***Planning Department  
Transportation Development Services***

**Re: Santa Fe Tow Lot #13  
8101 Jacs Ln., NE  
Traffic Circulation Layout**  
Engineer's/Architect's Stamp dated 11-17-15 (D16-D002A5)

SANTA FE TOW, ARMANDO BELTRAN — TRAFFIC CIRCULATION LAYOUT (TCL)

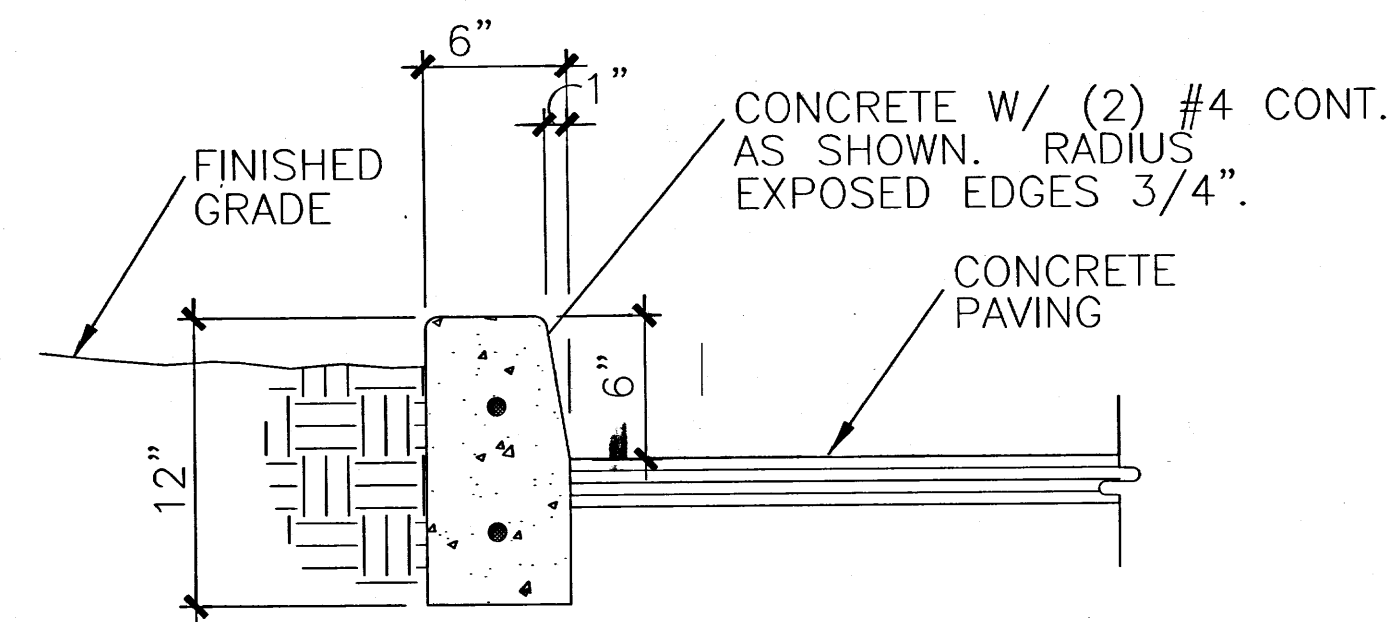
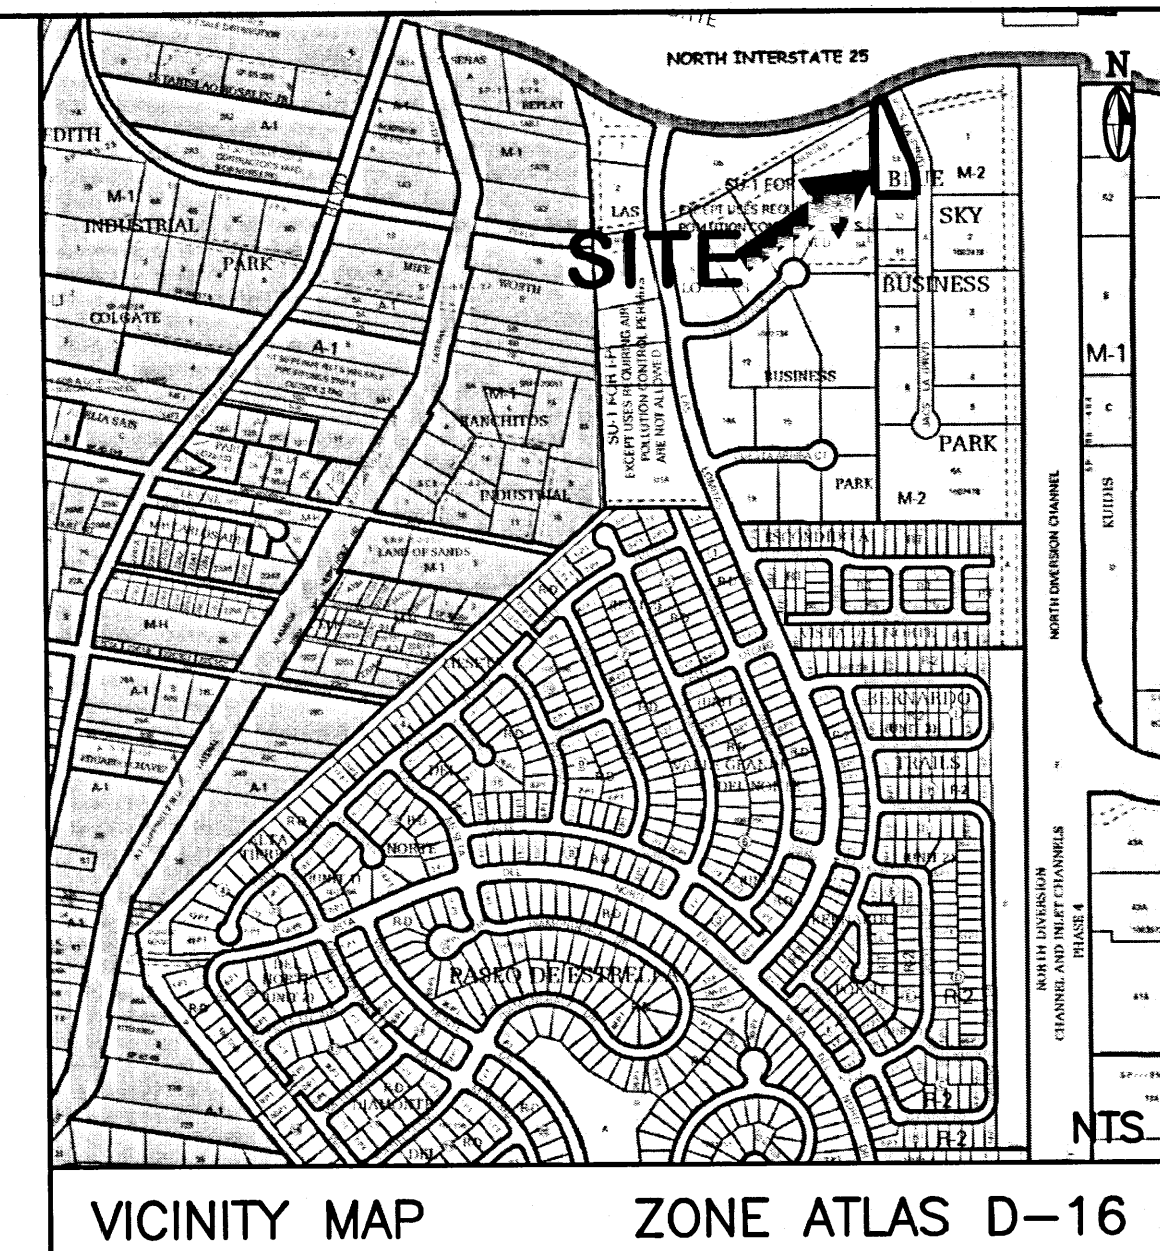
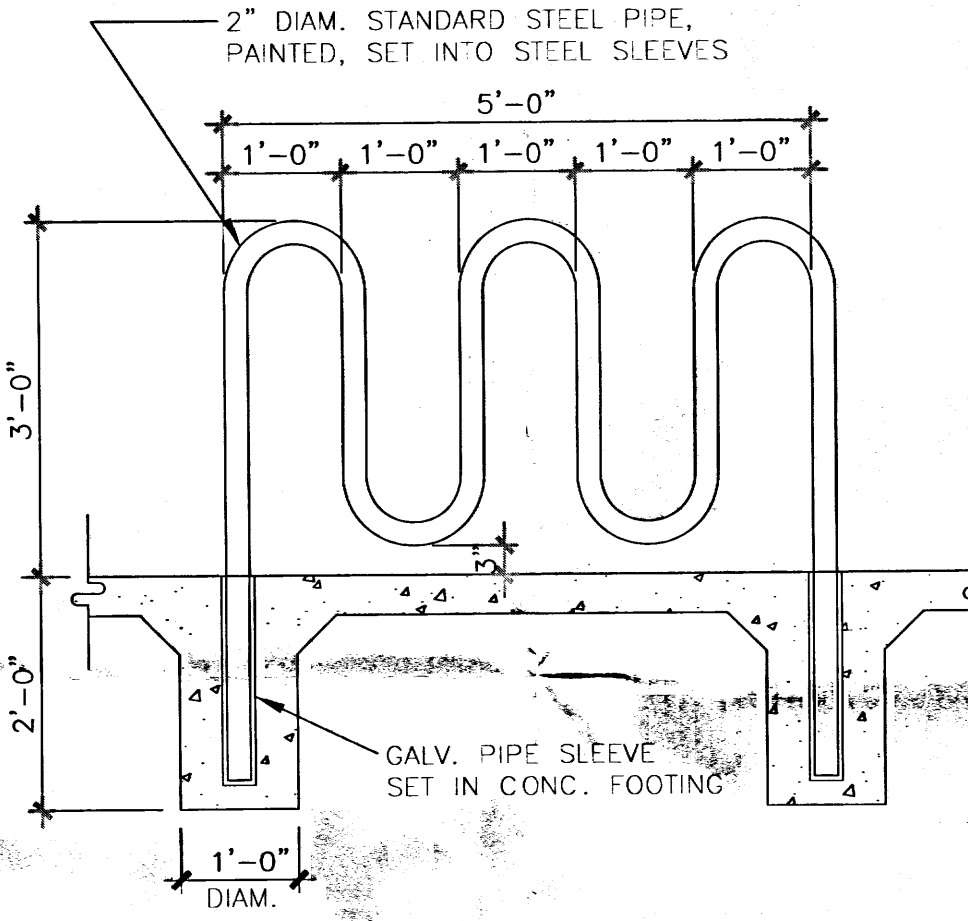
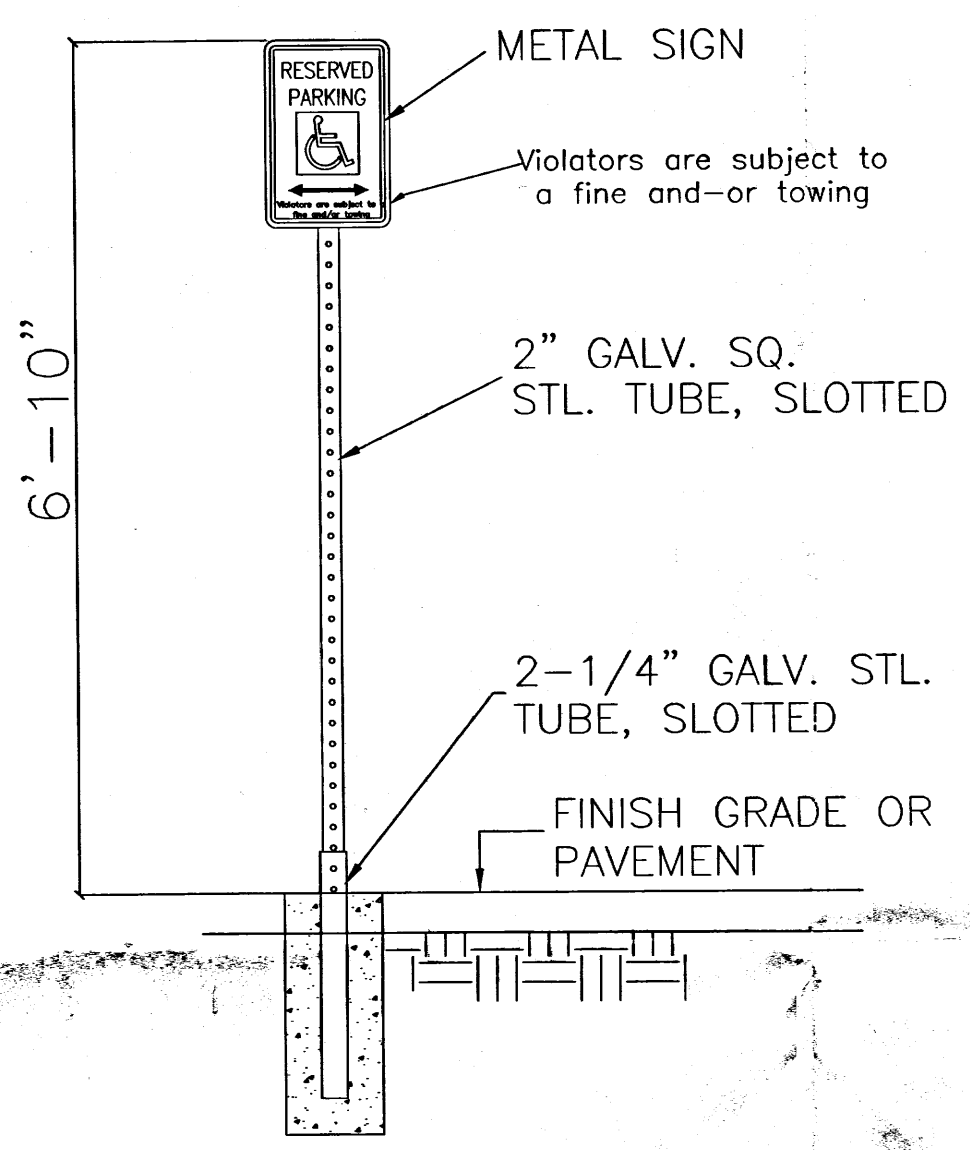
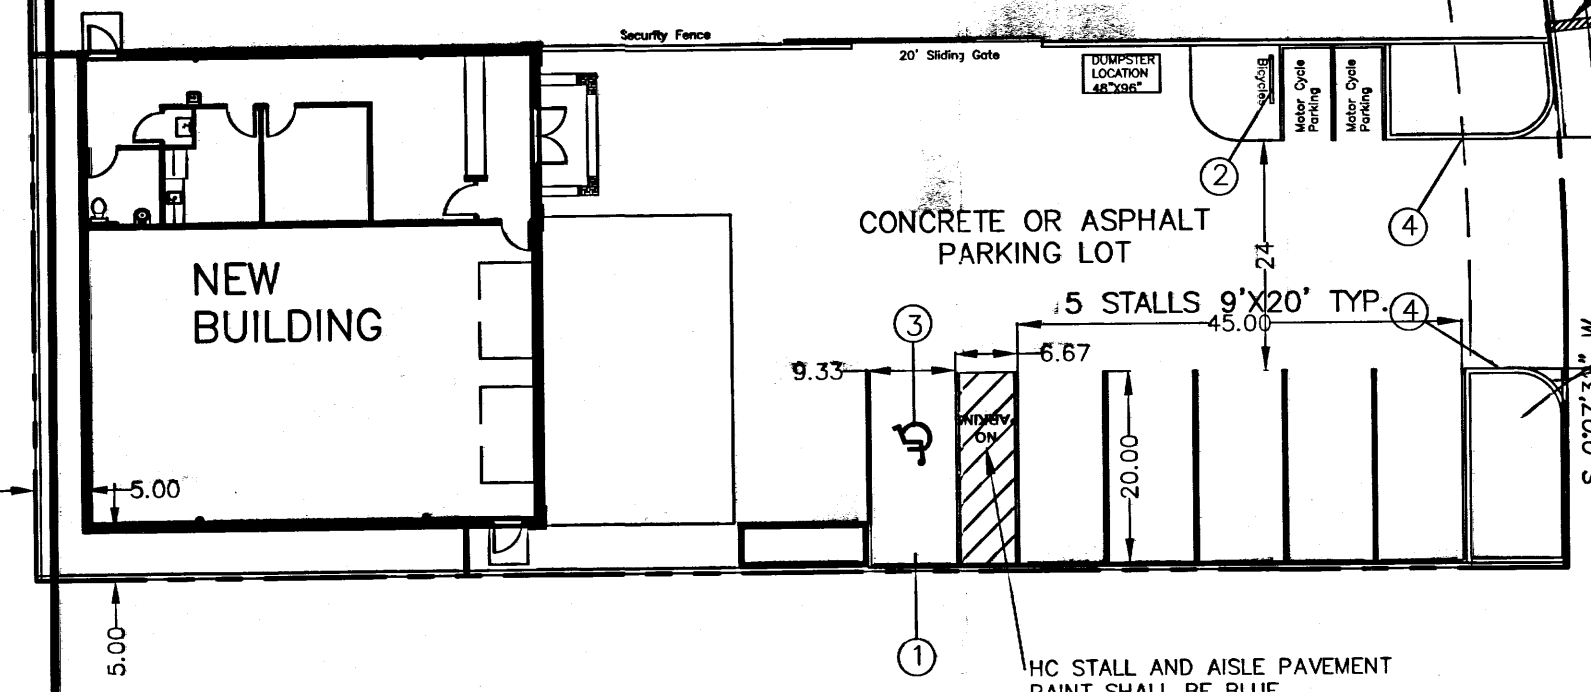
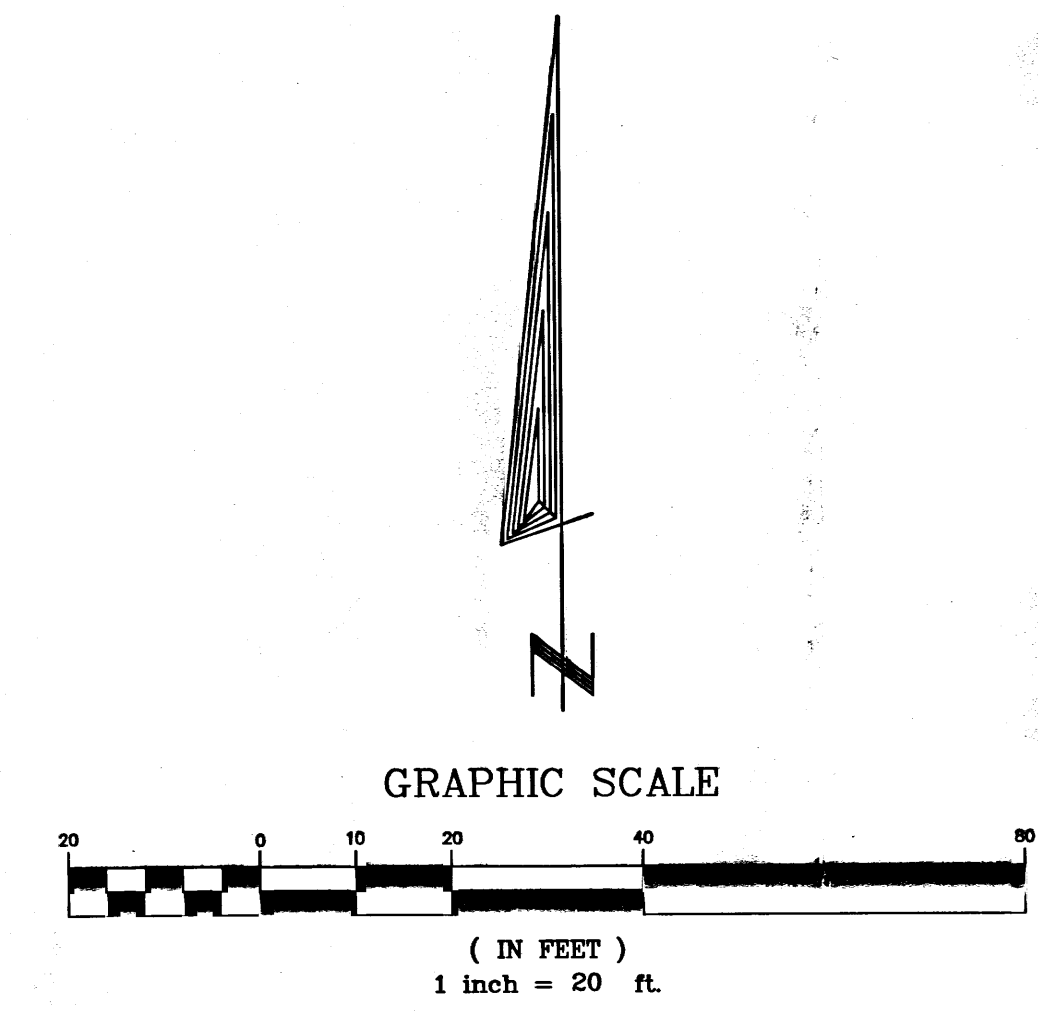
1. Please identify all existing buildings, doors, sidewalks, curbs, drive pads, walls and anything that influences the parking and circulation on the site.

2. Show all drive aisle widths and radii.
3. Please detail the width of the proposed drive pad.
4. Please detail the ADA ramps and sidewalk from the Public R.O.W.

5. Per the DPM, a 6 ft. wide ADA accessible pedestrian pathway is required from the public sidewalk to the building entrances. Please clearly show this pathway and provide details.

6. Per the DPM, a 6 ft. wide ADA accessible pedestrian pathway is required from the HC parking stall access aisles to the building entrances. Please clearly show this pathway.

7. Provide a min 6" or max 8" high concrete barrier curb or other acceptable barrier between landscaping and parking areas and/or drive aisles.
8. Design delivery vehicle route needs to be shown.

9. Service vehicle and/or refuse vehicle maneuvering must be contained on-site; provide a copy of refuse approval.

10. Please provide a sight distance exhibit (see the *Development Process Manual, Chapter 23, Section 3, Part D.5 Intersection Sight Distance*). Please show this detail for the entrance/exit on Jacs Ln.

11. Please add the following note to the clear sight triangle: "Landscaping and signage will not interfere with clear sight requirements. Therefore, signs, walls, trees, and shrubbery between 3 and 8 feet tall (as measured from the gutter pan) will not be acceptable in this area."
12. Please include two copies of the traffic circulation layout at the next submittal.
